WEST SUSSEX COUNTY COUNCIL CONSULTATION

TO:	Arun District Council FAO: Katie Sharp
FROM:	WSCC - Highway Authority
DATE:	7th June 2022
LOCATION:	Central Wetland Area Hampton Park Toddington Lane Littlehampton BN17 7PL
SUBJECT:	LU/369/21/RES Approval of reserved matters following outline consent LU/47/11/ (amended under LU/182/15/PL) for the main on-site infrastructure at Hampton Park and encompasses: 1) the Central Wetland Area, 2) the main spine road and crossing structures & 3) the SUDs features. Revised plans received.
DATE OF SITE VISIT:	n/a
RECOMMENDATION:	More information required
S106 CONTRIBUTION TOTAL:	SEE LATEST VERSION OF S106 AGREEMENT

This is the fourth WSCC County Highways (CHA) response to the above planning application for approval of reserved matters following outline consent LU/47/11/ (amended under LU/182/15/PL) for the main on-site infrastructure at Hampton Park and encompasses: 1) the Central Wetland Area, 2) the main spine road and crossing structures & 3) the SUDs features.

Pile Cap - Plan View
Scale 1:100

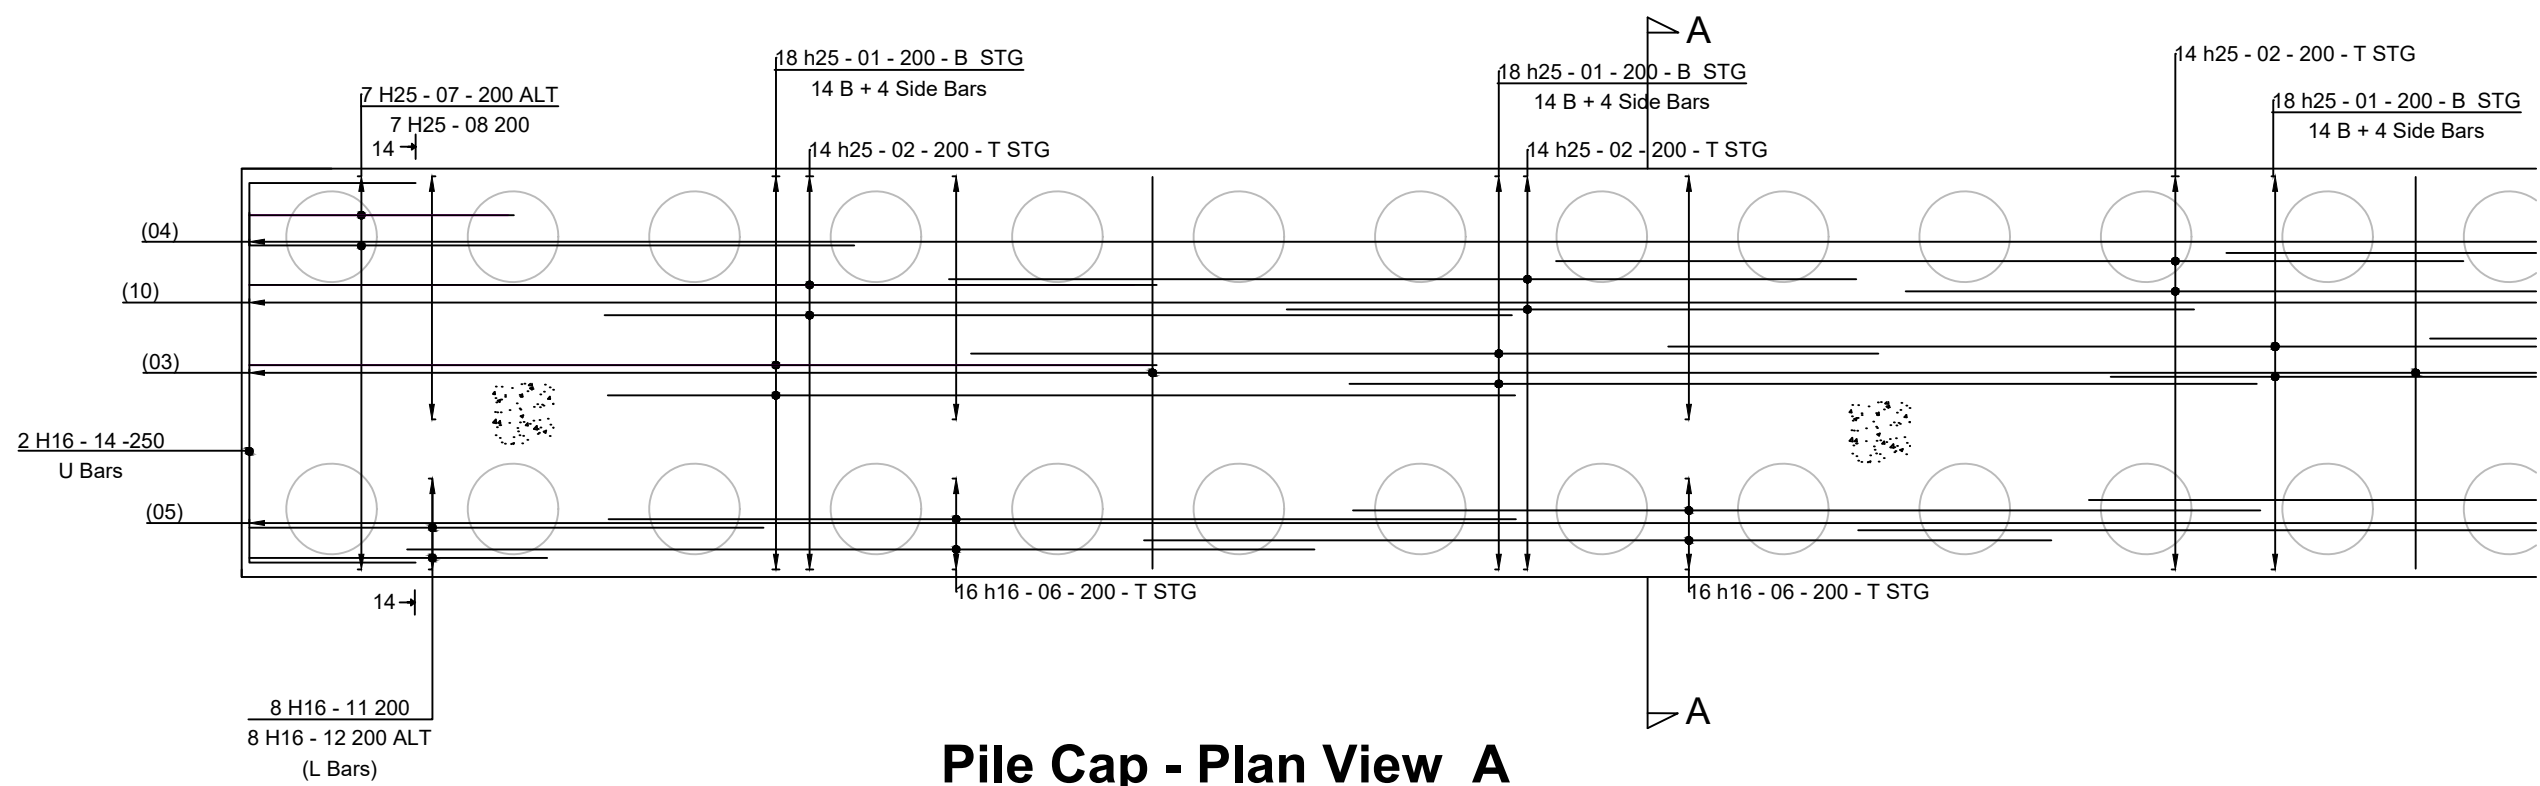
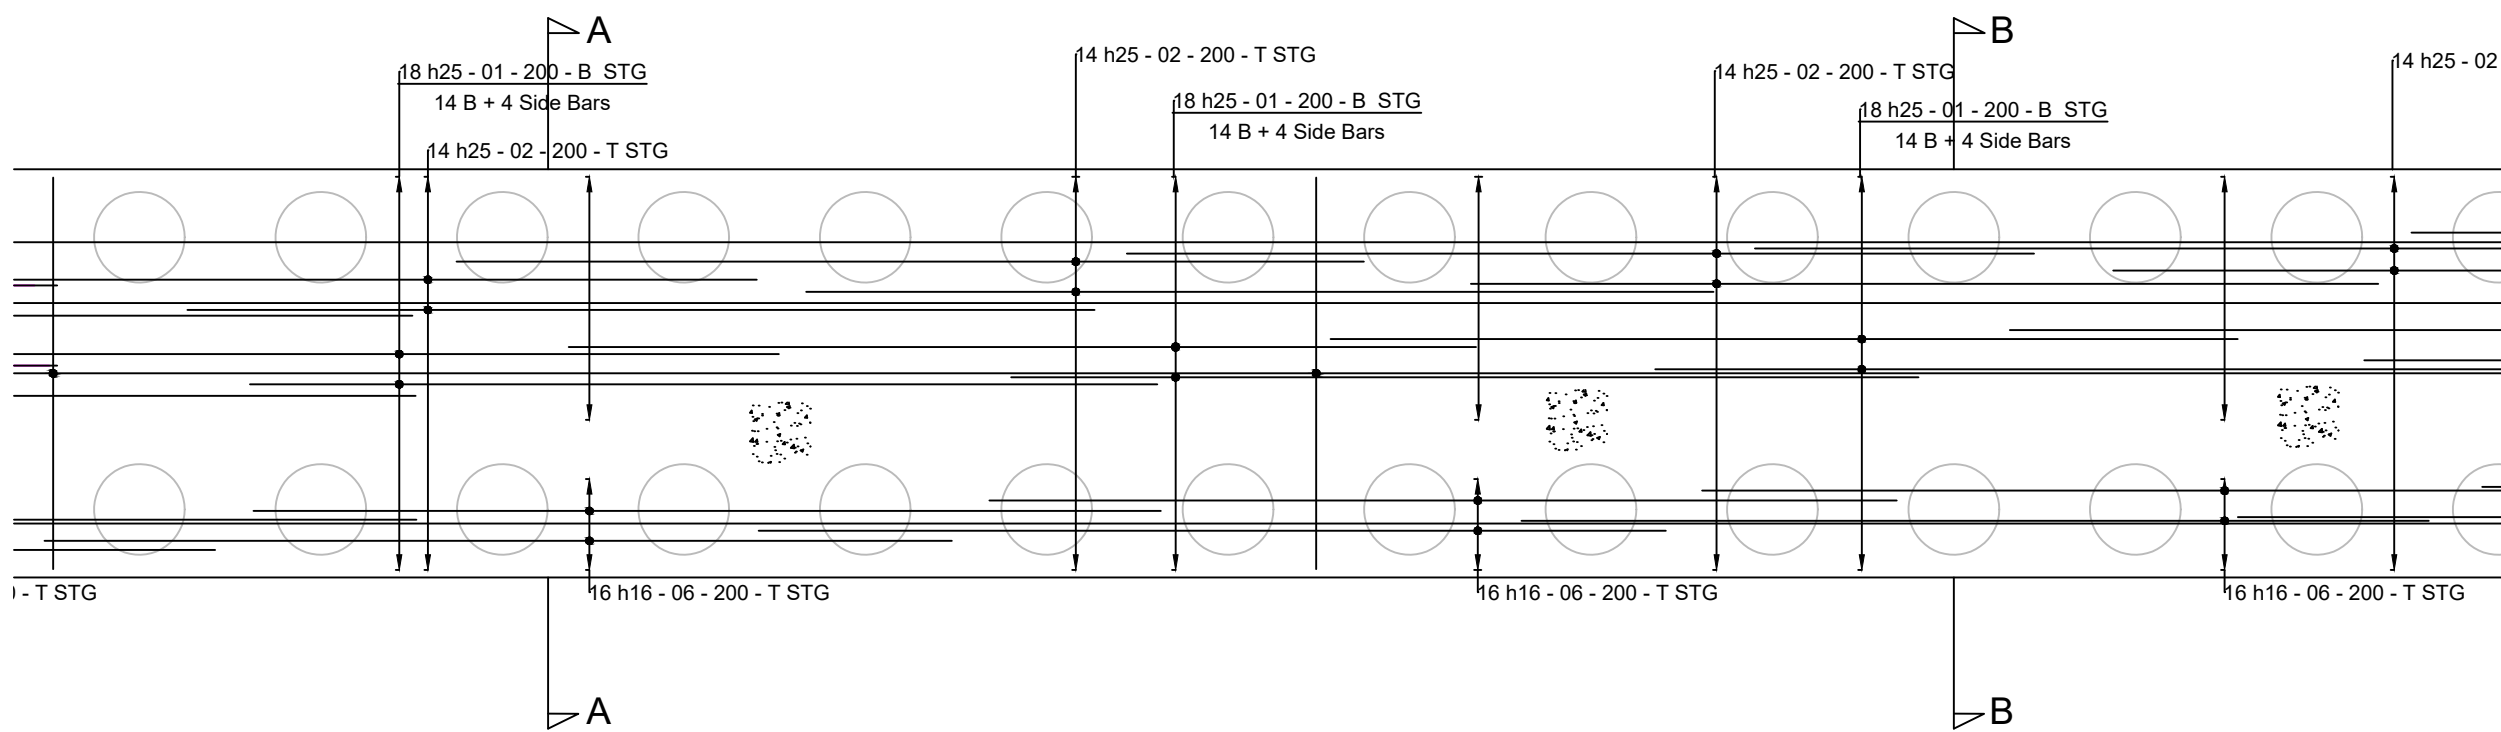
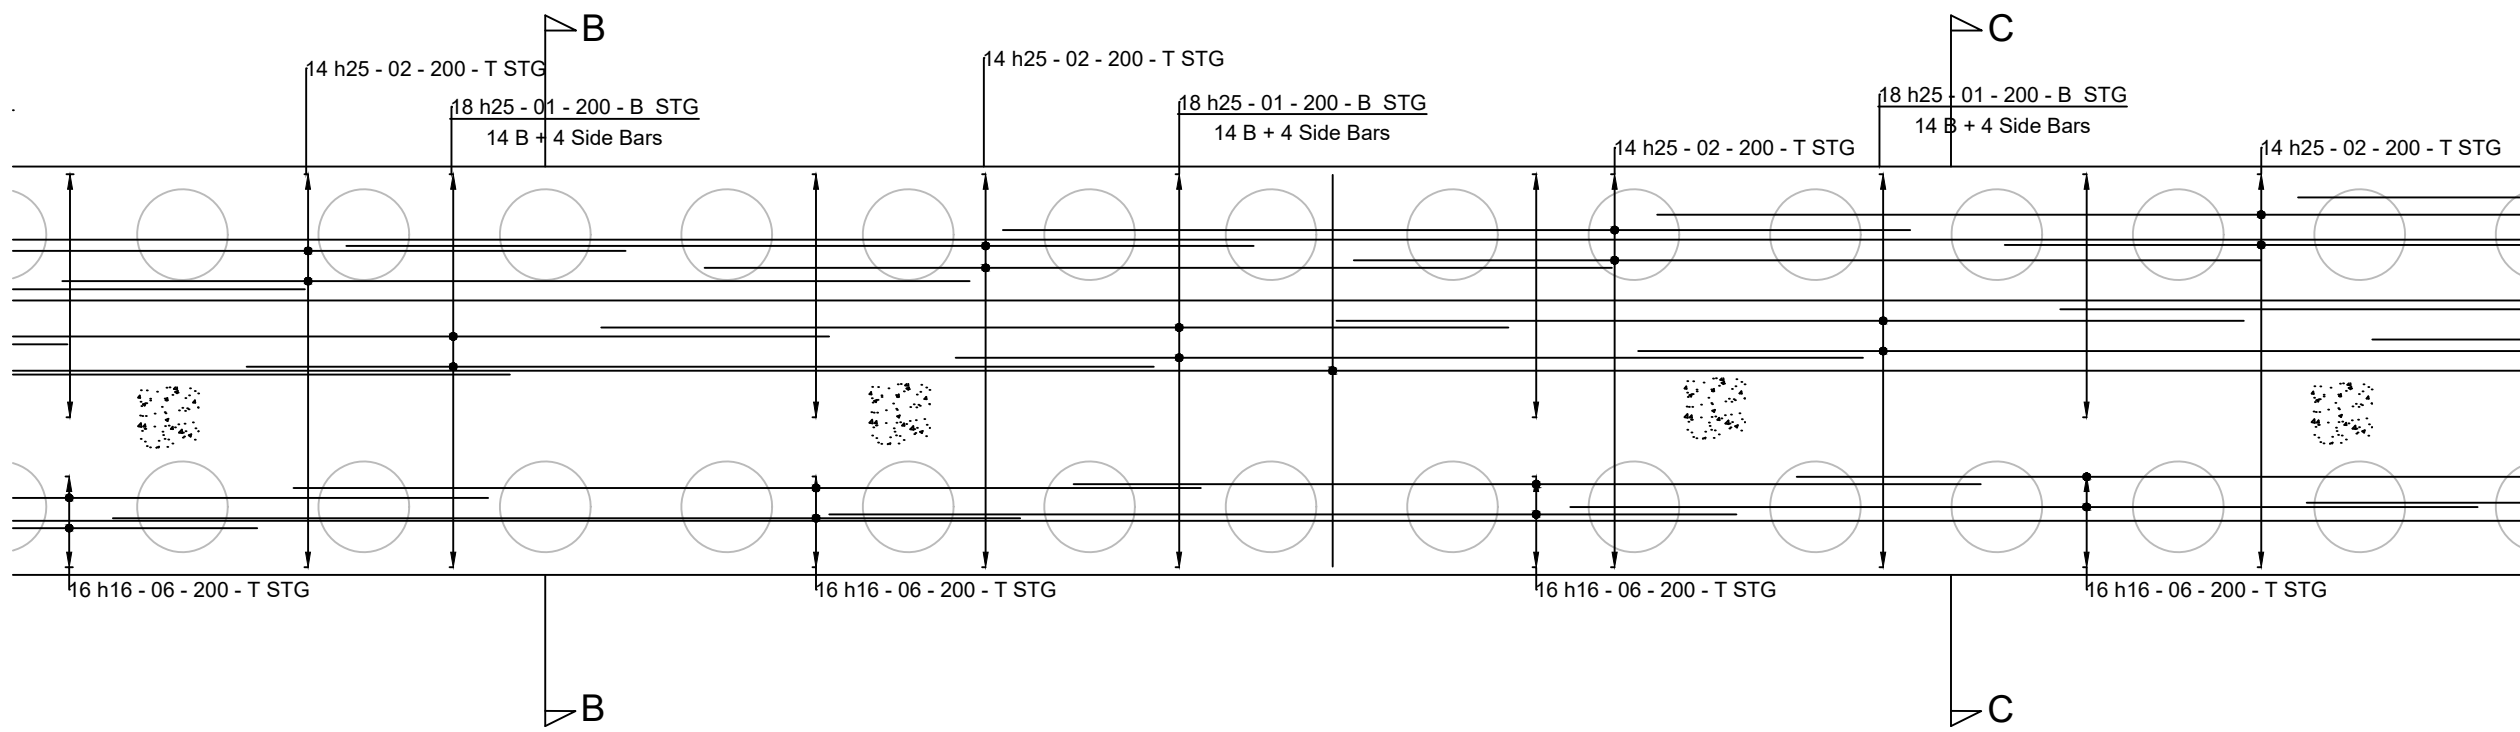
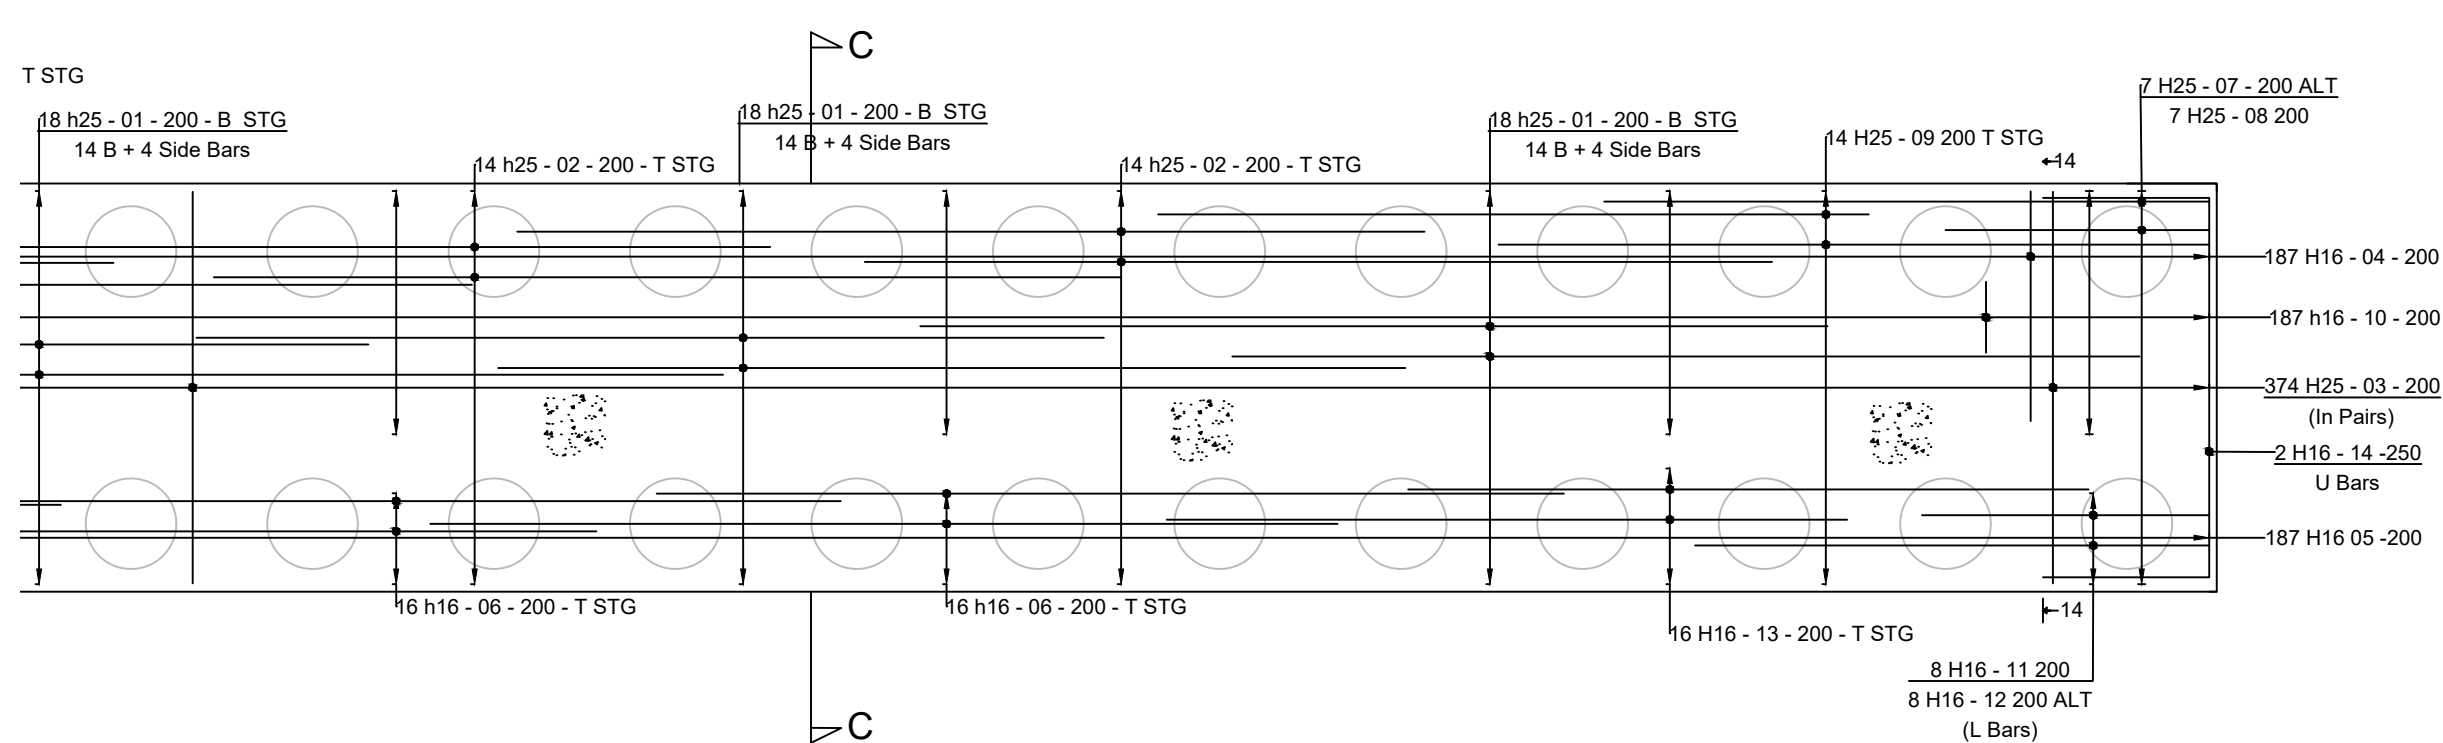
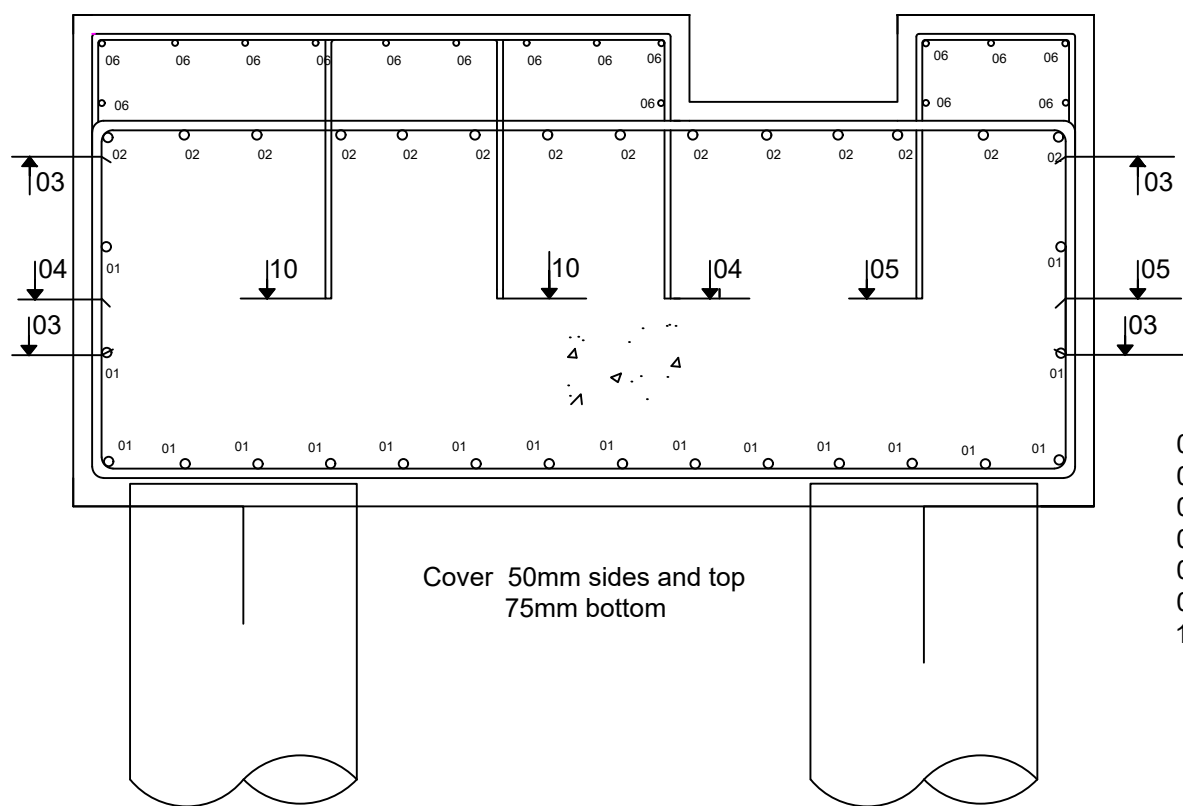
2. There's a drg. for the piles and piles caps (drg. 2231-001 & 002) that WSCC hasn't seen previously but wouldn't expect to see until the awaited Design and Check submission (which will also require approval) prior to construction.
